THE SHOPS AT FILING NO. 2 AT MERIDIAN RANCH

PHOTOMETRIC PLAN

Shop's @ Meridian
Site Development Plan
Ranch
11810 Stapleton Drive
Falcon, CO

FILE NUMBER: PPR18033

PHOTOMETRIC PLAN

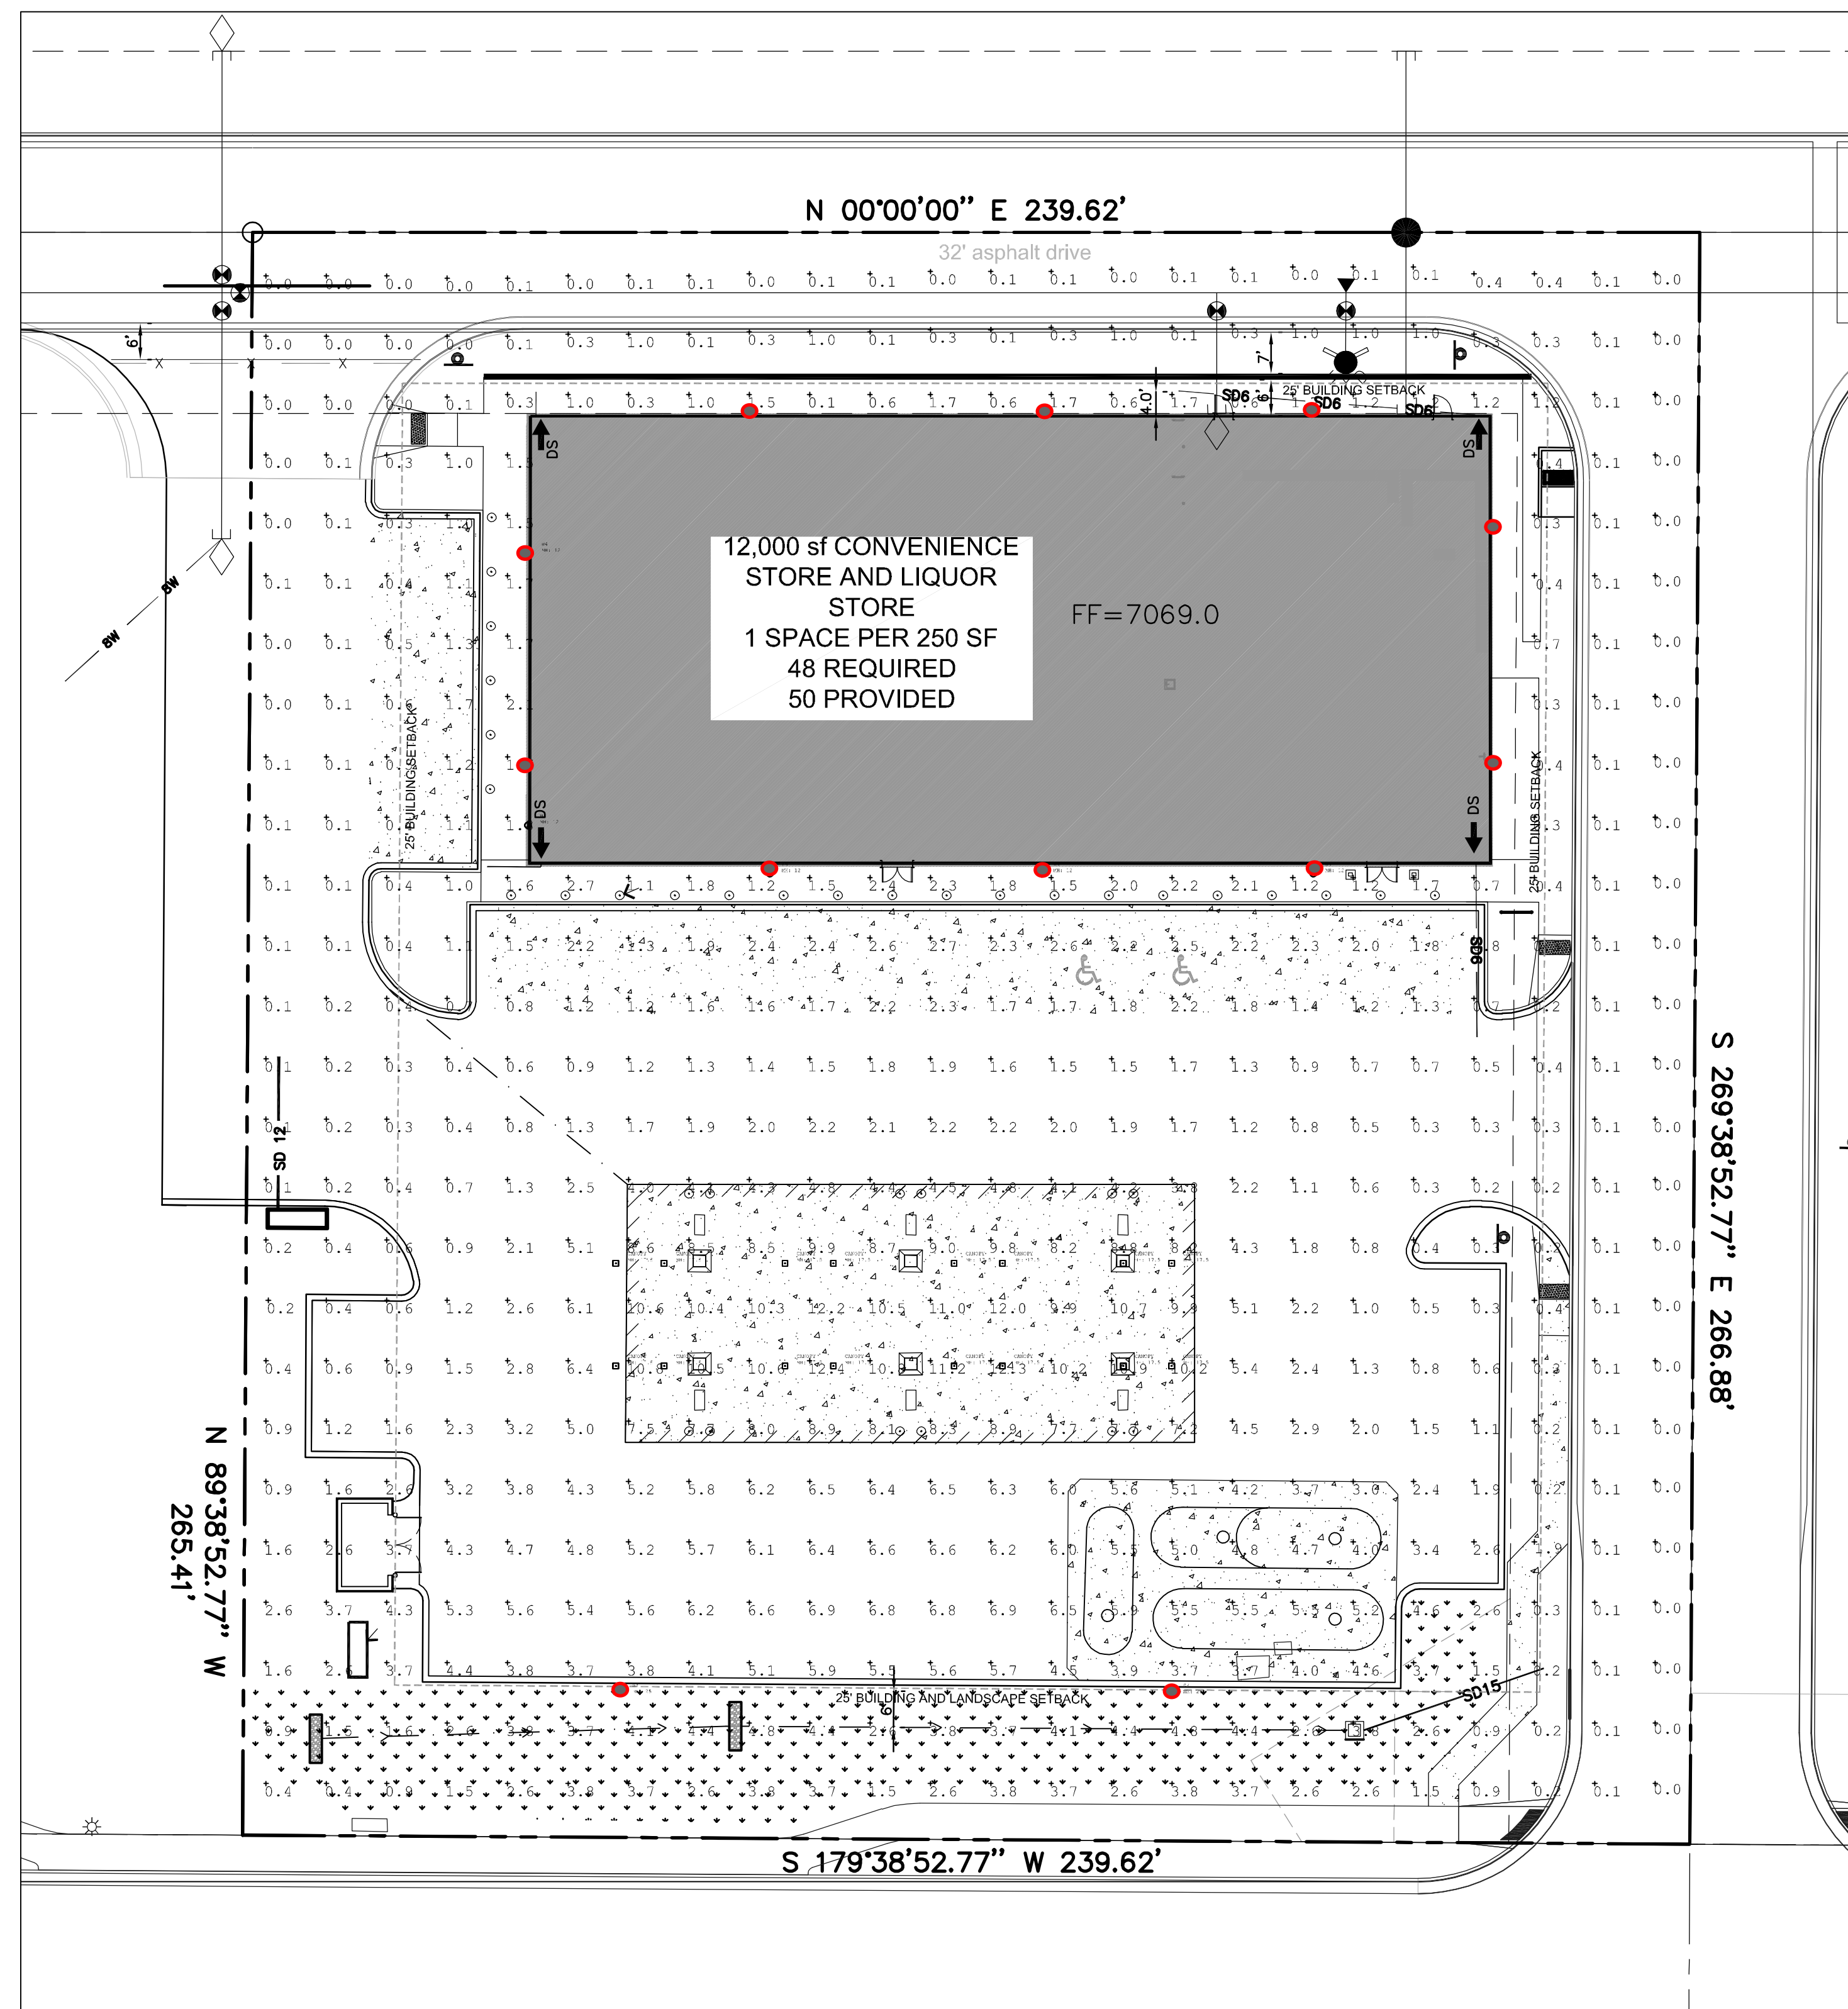
Per previous comment, you need to show that the foot candles are less than 0.1 at property boundaries where adjacent to residential property or public right-of-way (i.e. Stapleton).

These don't correspond with the lights identified in the legend.
